From: [Rich Elliott](#)
To: [Chace Pedersen](#)
Cc: [Dan Young](#); [Joe Delvo](#); [Dan Johnson](#); [Jeremy Haberman](#)
Subject: RE: [Ext] SP-23-00005 Craig - Notice of Application
Date: Tuesday, July 18, 2023 8:51:40 AM

KVFR has the following input:

CDS is requesting comment on the following short plat application: SP-23-00005 Craig. Links to the file materials can be found below. The comment period will end **Monday, August 2, 2023, at 5pm**. CDS will assume your agency does not wish to provide comment if not received by this date. Please let me know if you have any issues accessing the materials.

SWEETWATER SHORT PLAT
PART OF SECTION 29, T. 19 N., R. 19 E., W.M.
KITTITAS COUNTY, WASHINGTON

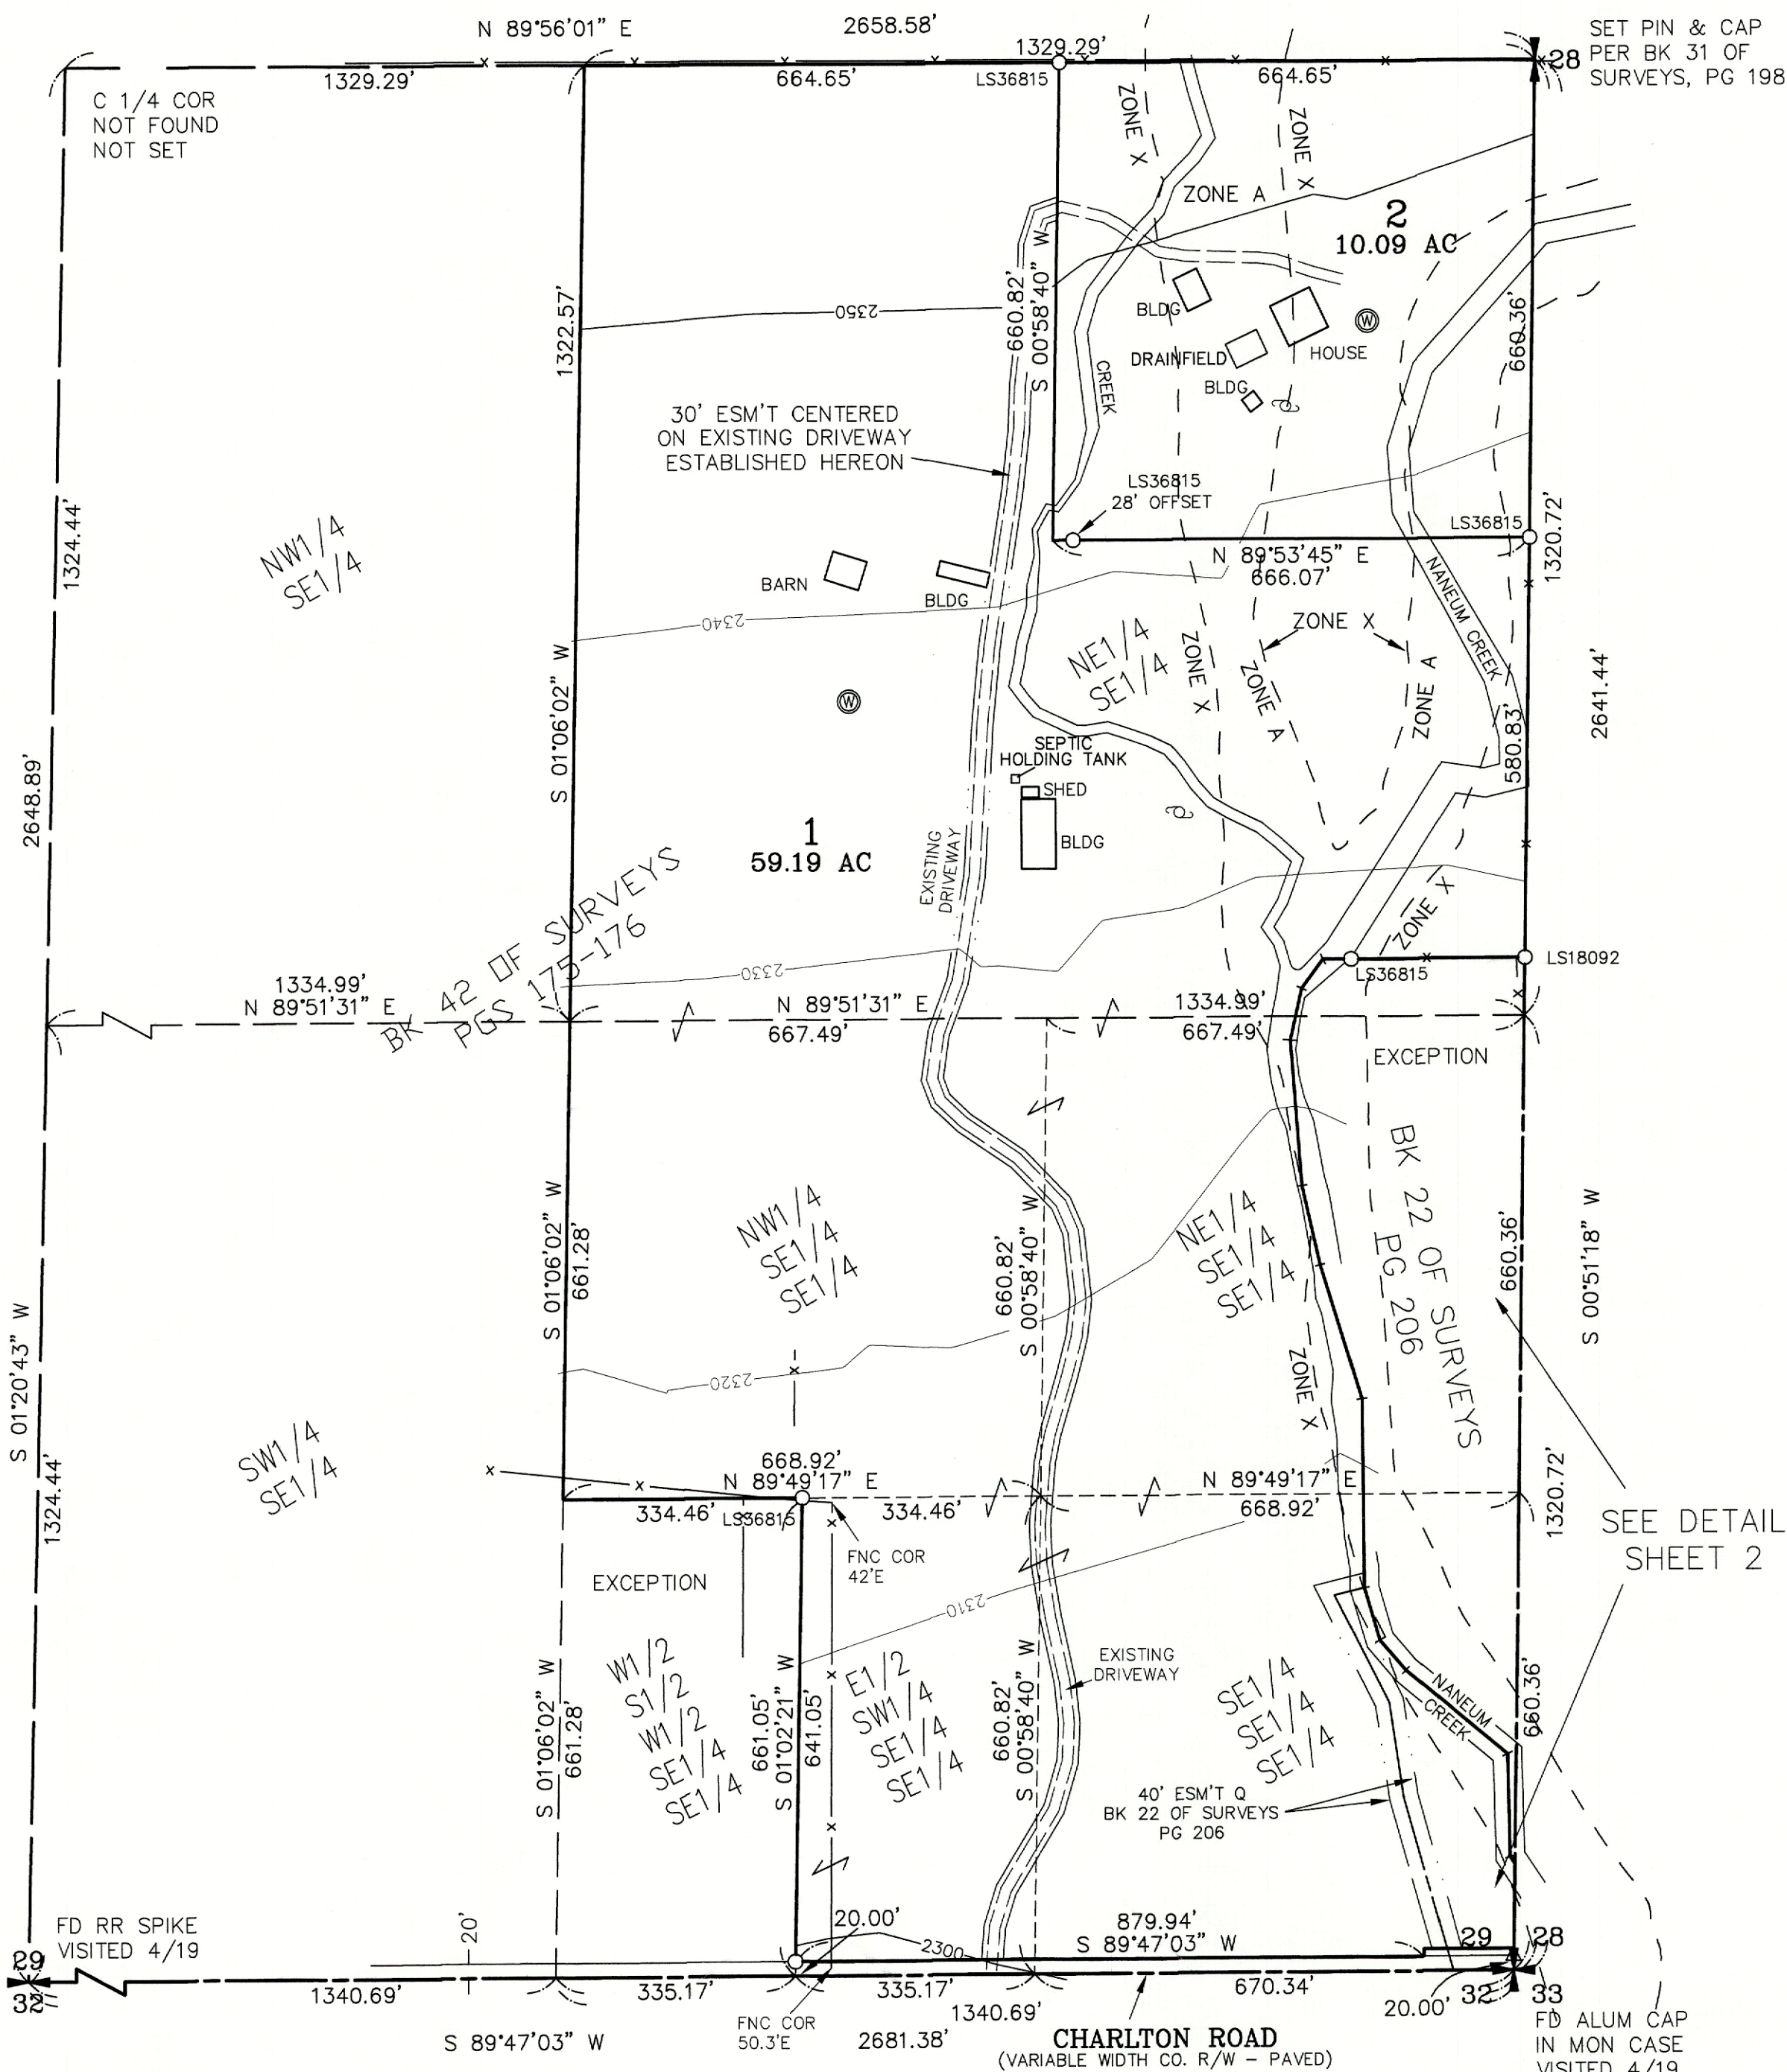
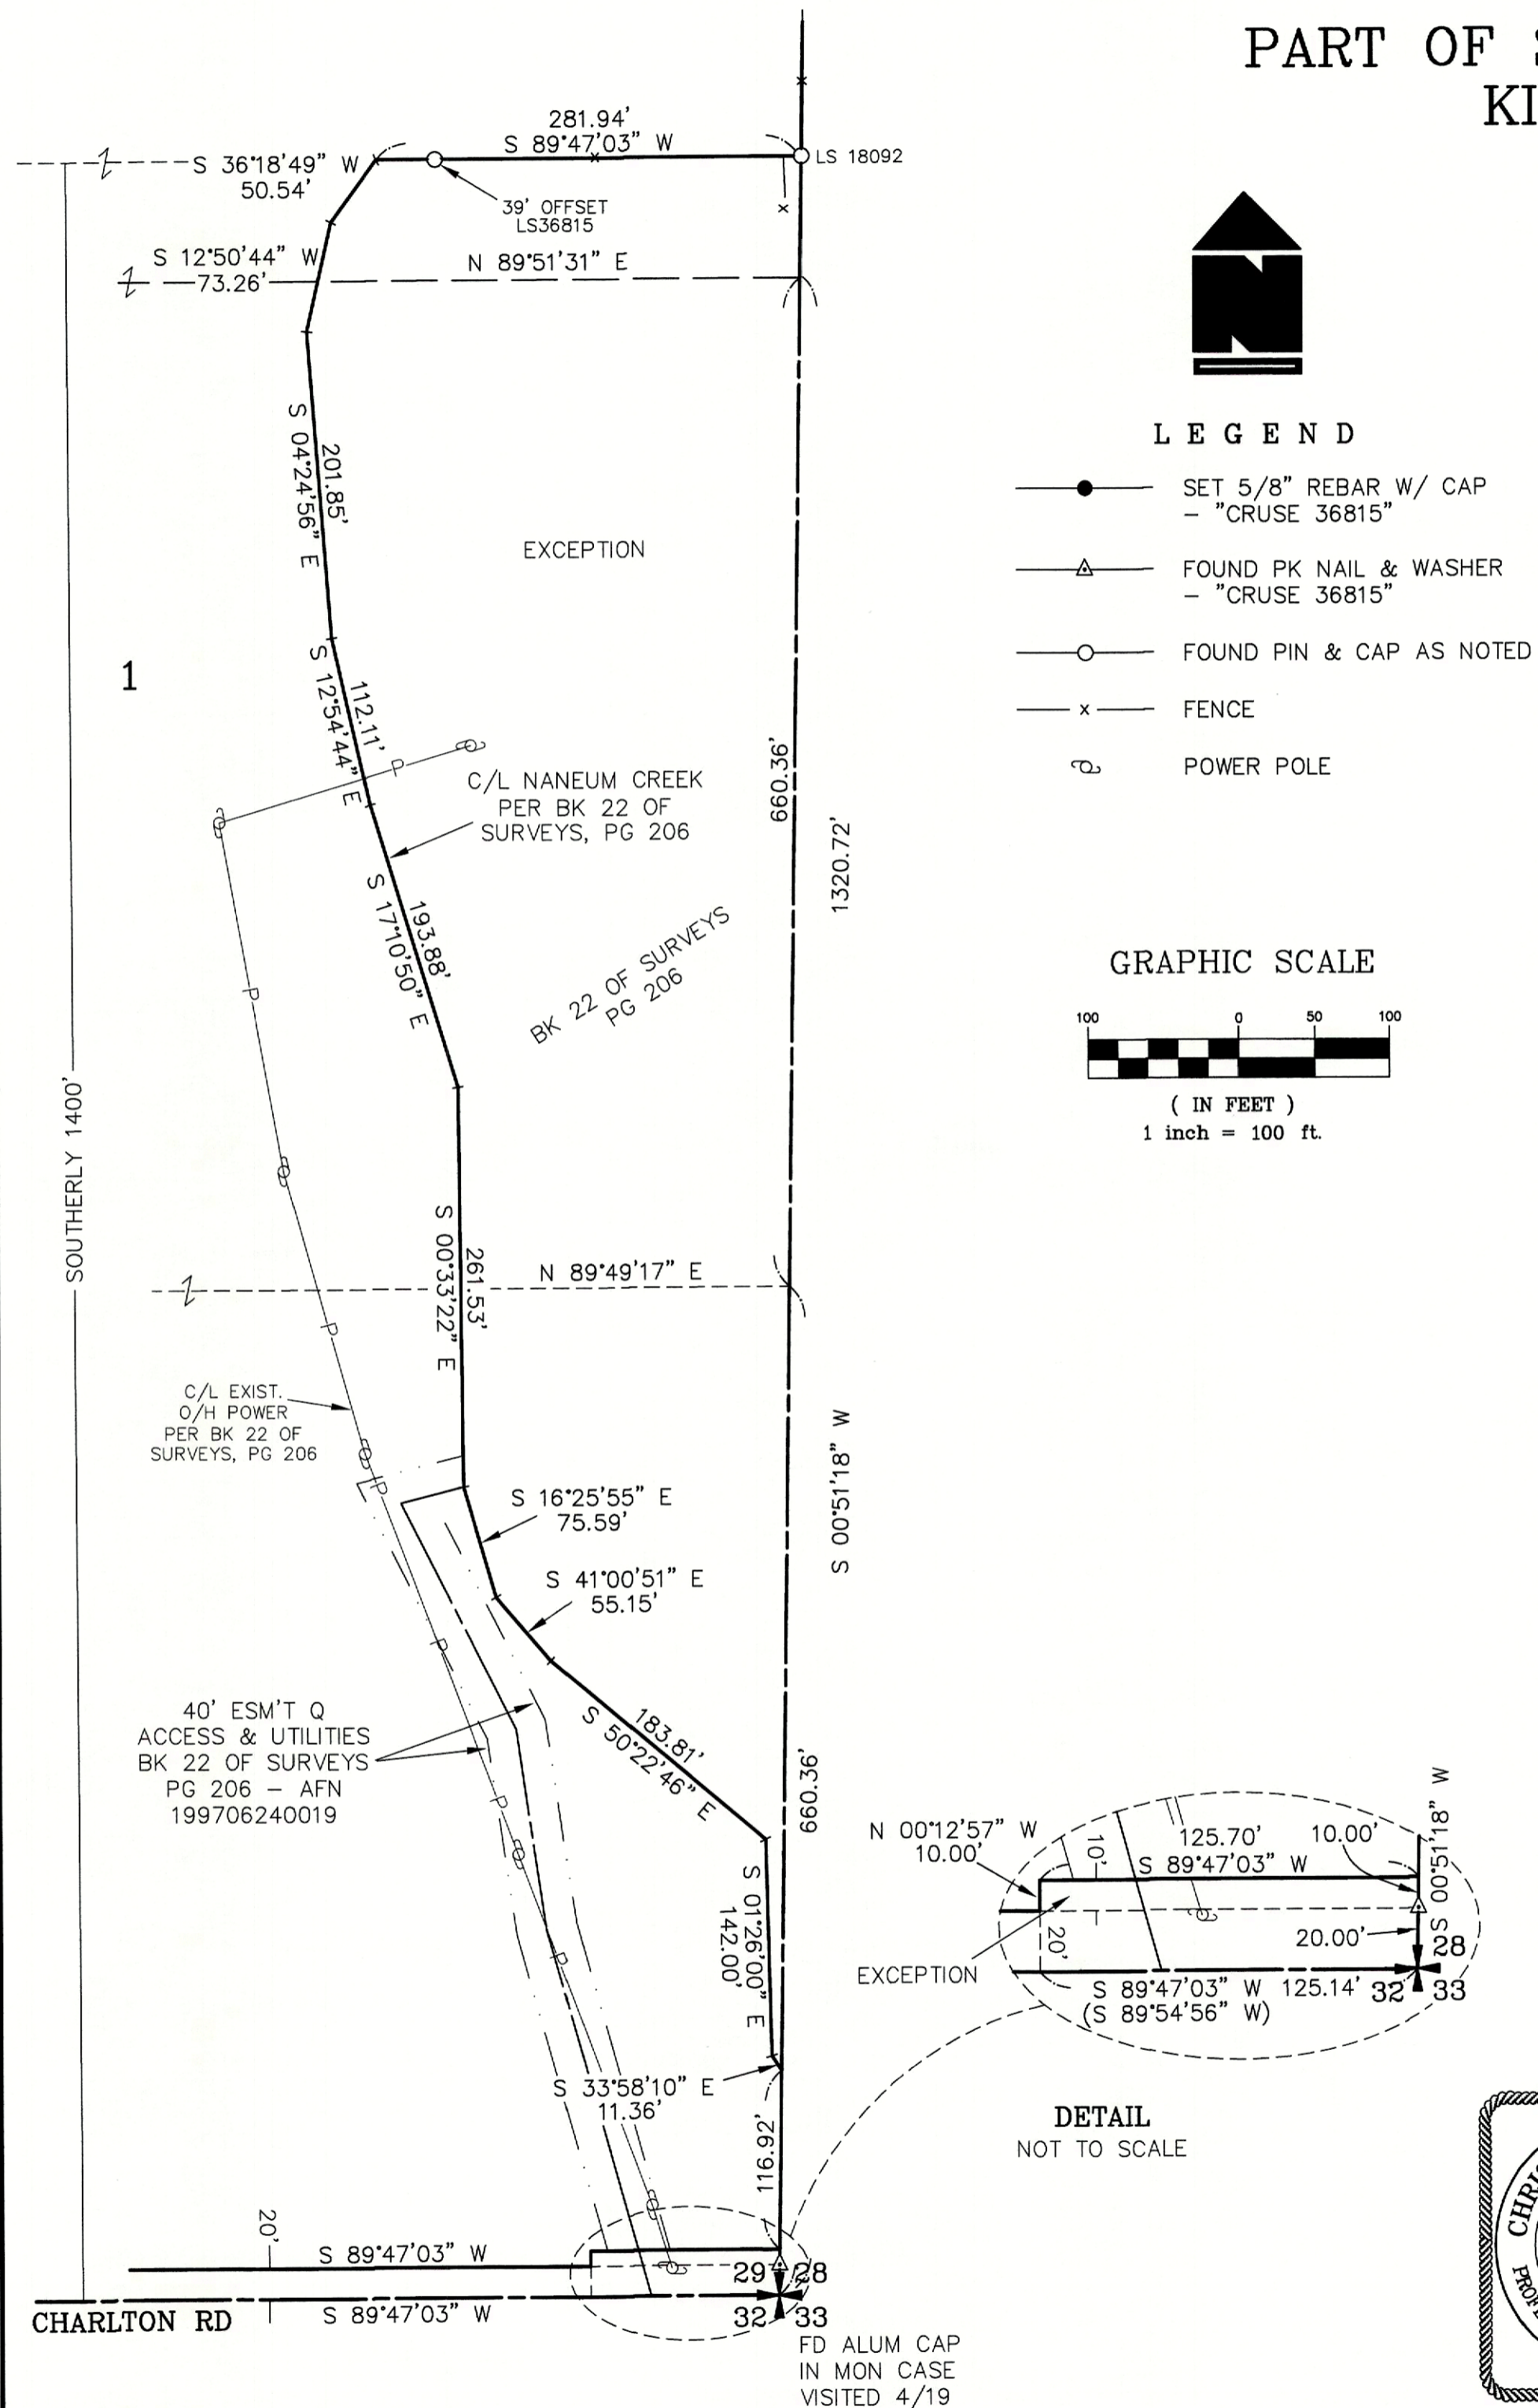
1. Access and turnarounds to both parcels must meet current IFC – Appendix D.
2. Addressing visible from both directions of travel on Charlton Road.
